From: Joseph Rexroad <joe.rexroad@Rexroadapg.com>
Sent: Monday, August 22, 2022 10:09 AM
To: Matthew Fitzsimmons
Cc: Kari Parsons
Subject: BOA-22-008 520 Empress - Dimensional Variance

1. What factors led the architects to believe the structure could not be built as an attachment to the existing structure as (presumably) was proposed 1/18/22 with the granting of the first variance? Why was this original proposal not completed as planned?

SHEET:  
SITE PLAN

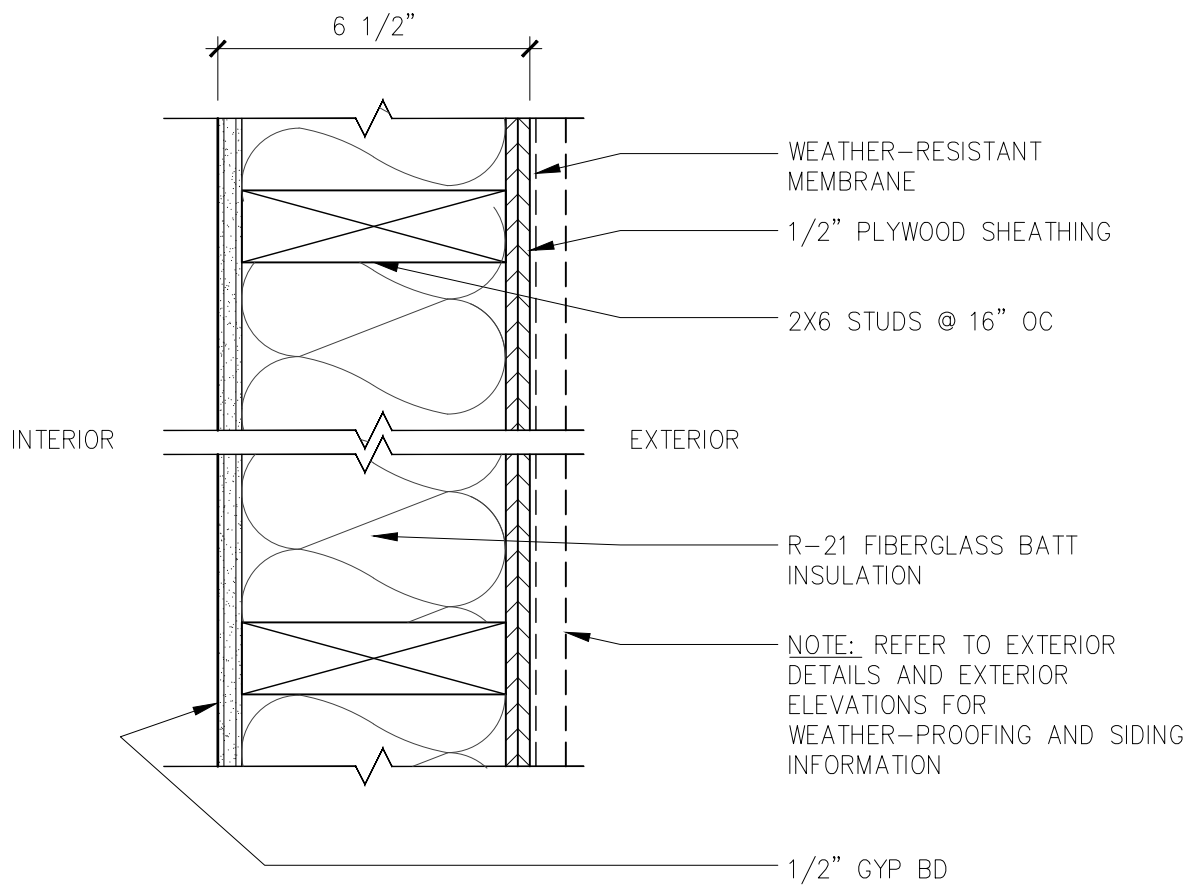
3. What is to become of the existing garage on the north corner of the house with no driveway providing access? Is a renovation of that space included in this construction effort?

SHEET:  
GARAGE PLANS

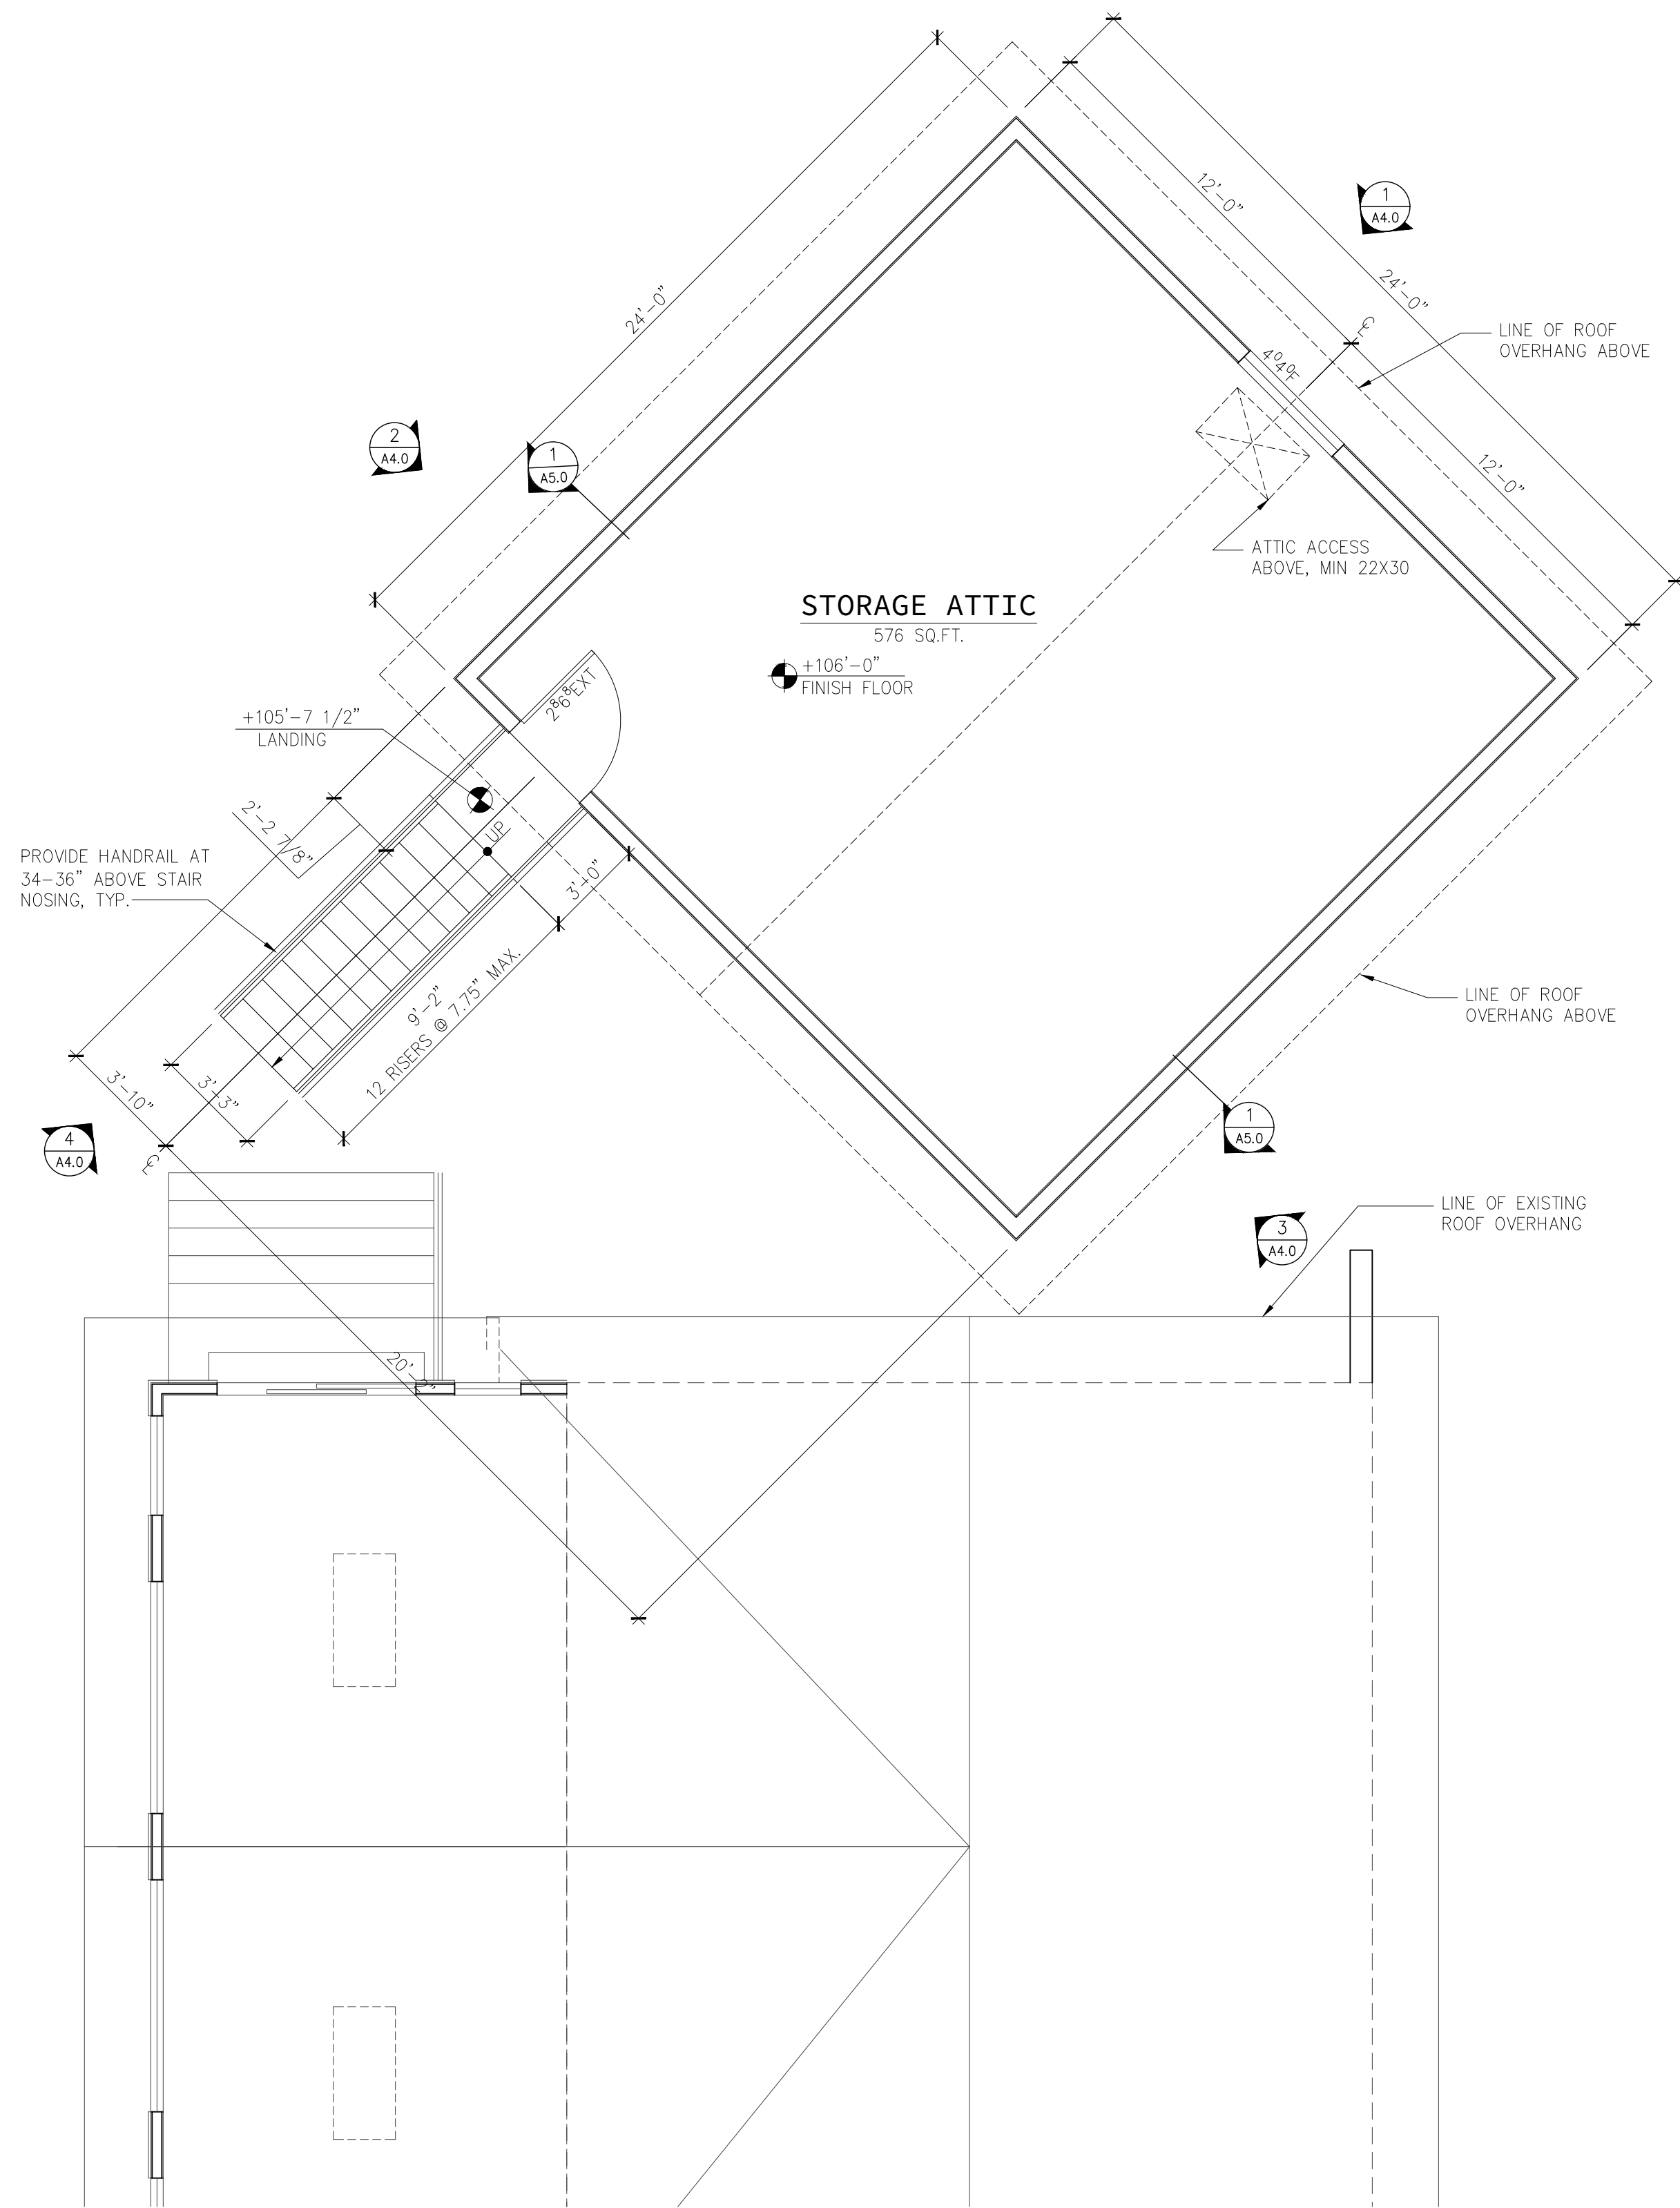
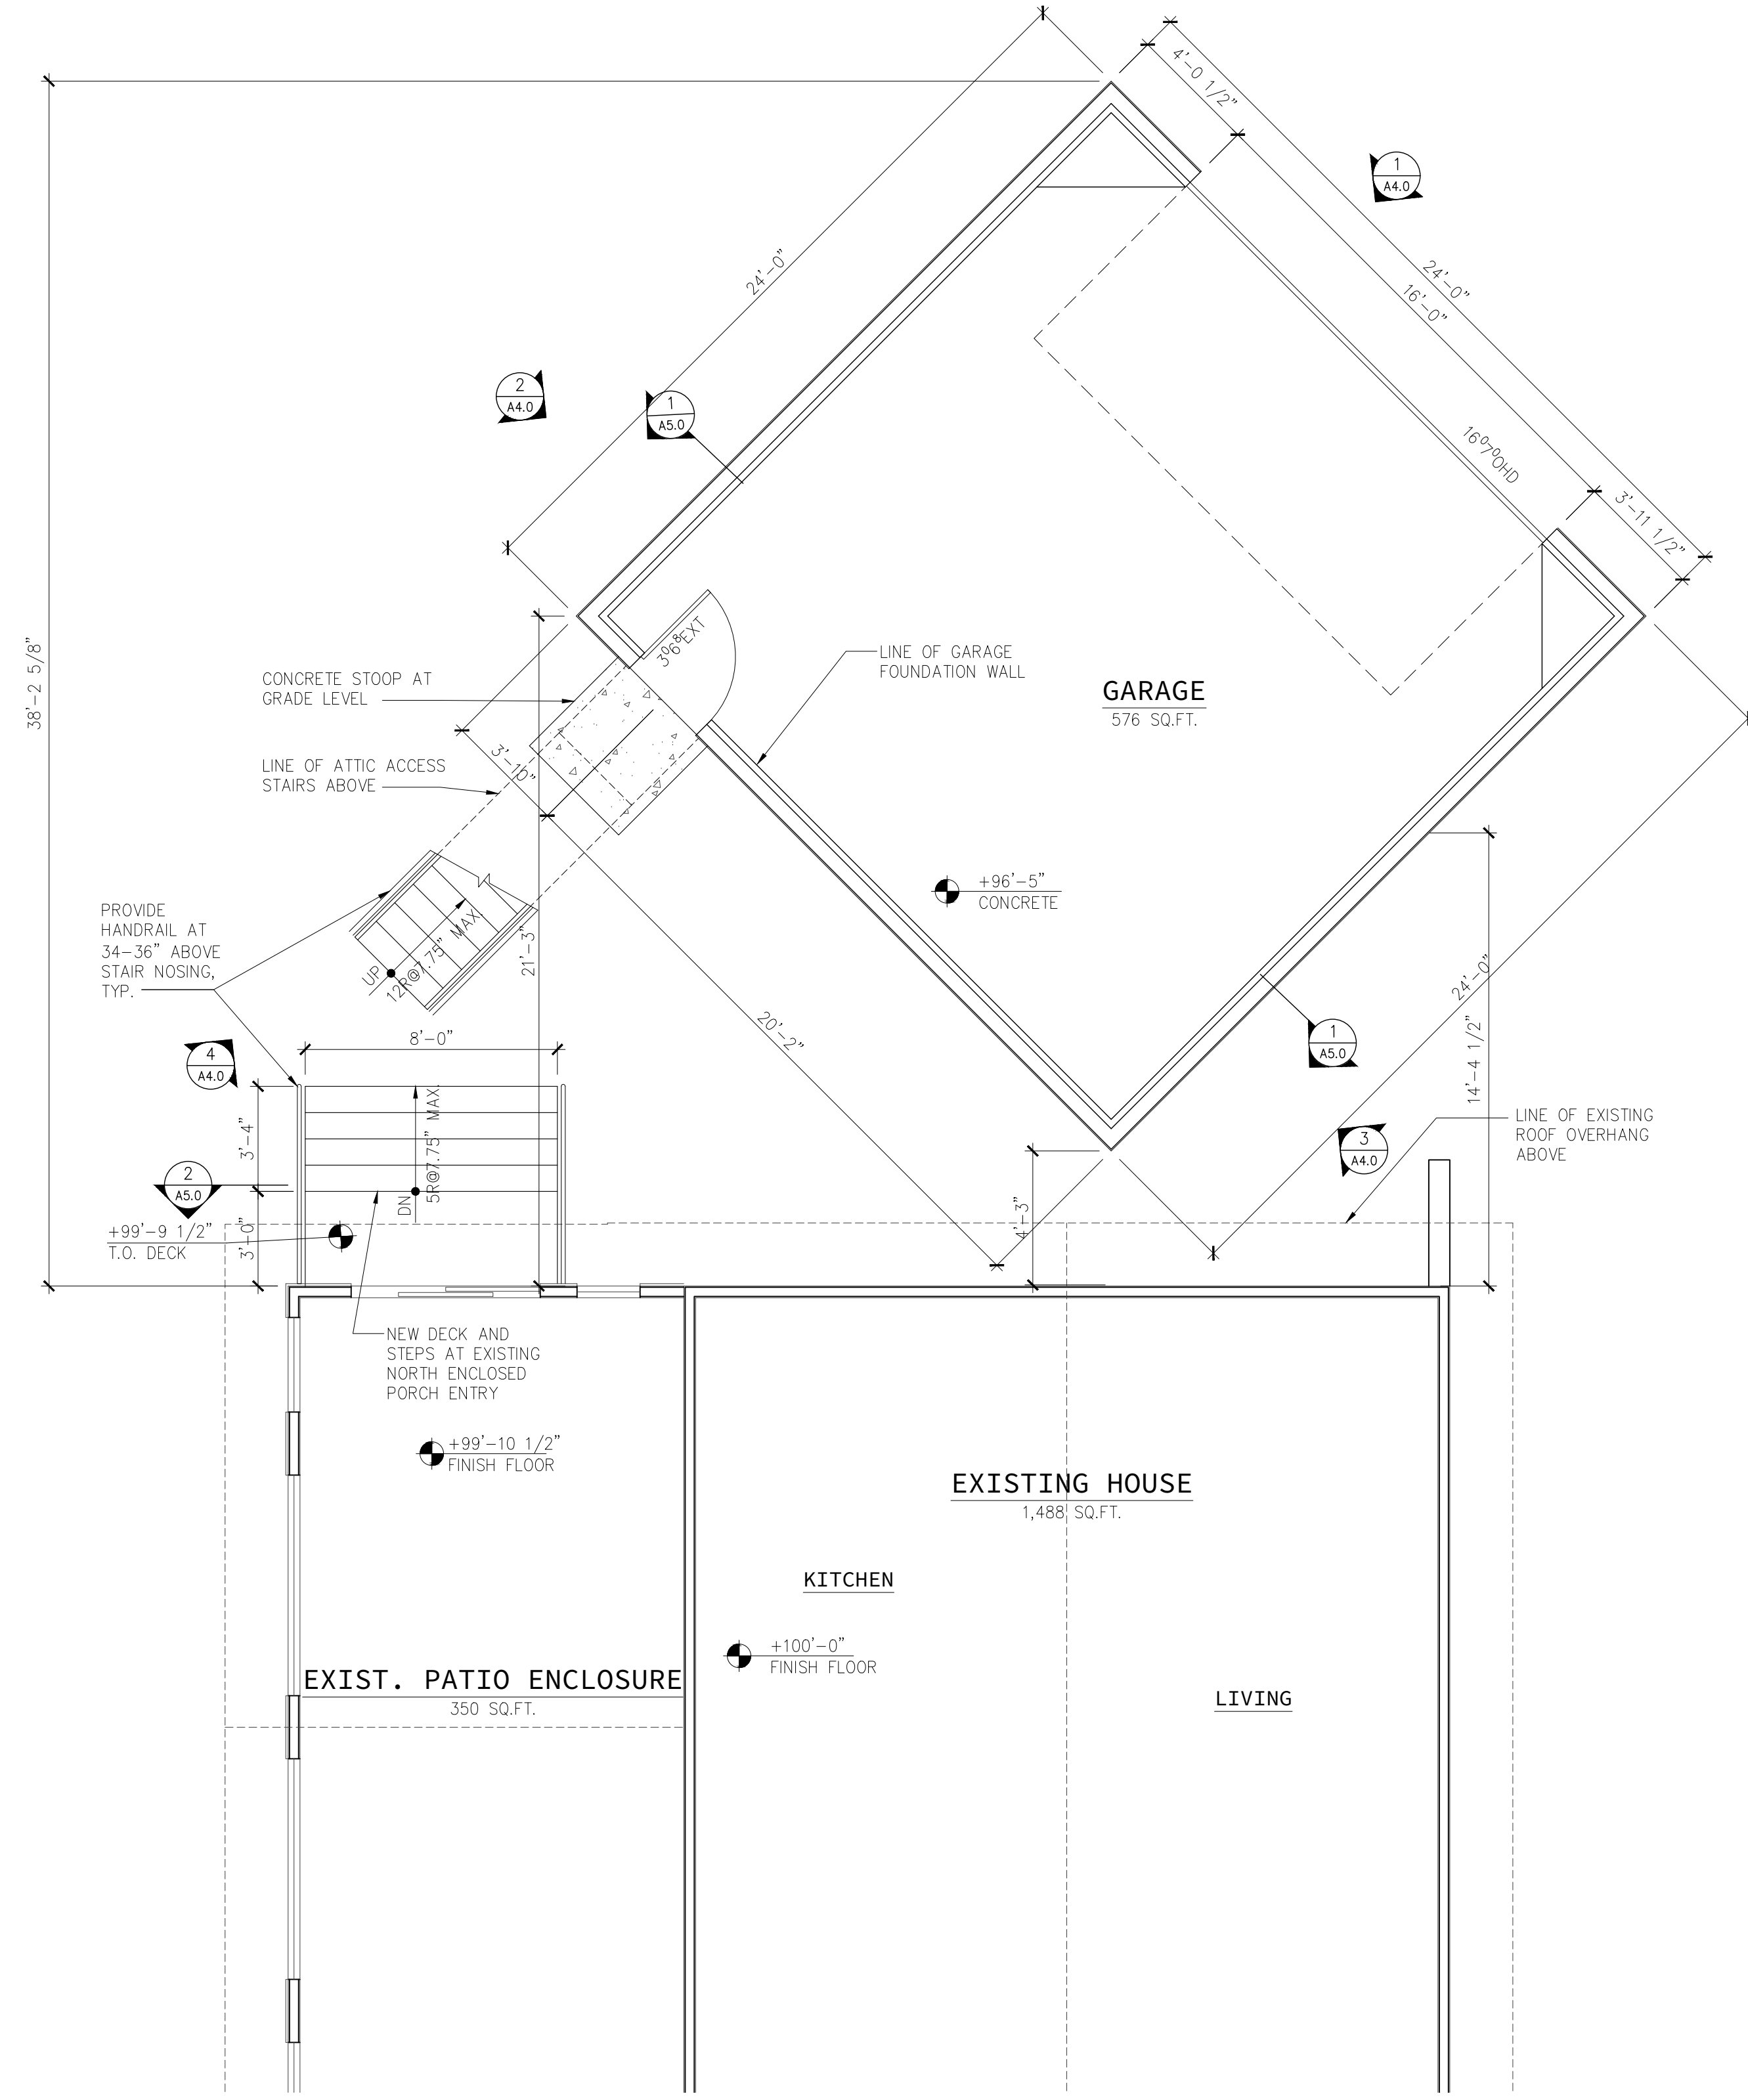
4. This is being called a garage, but in fact is a two-story structure, defined on plans as storage over a garage.
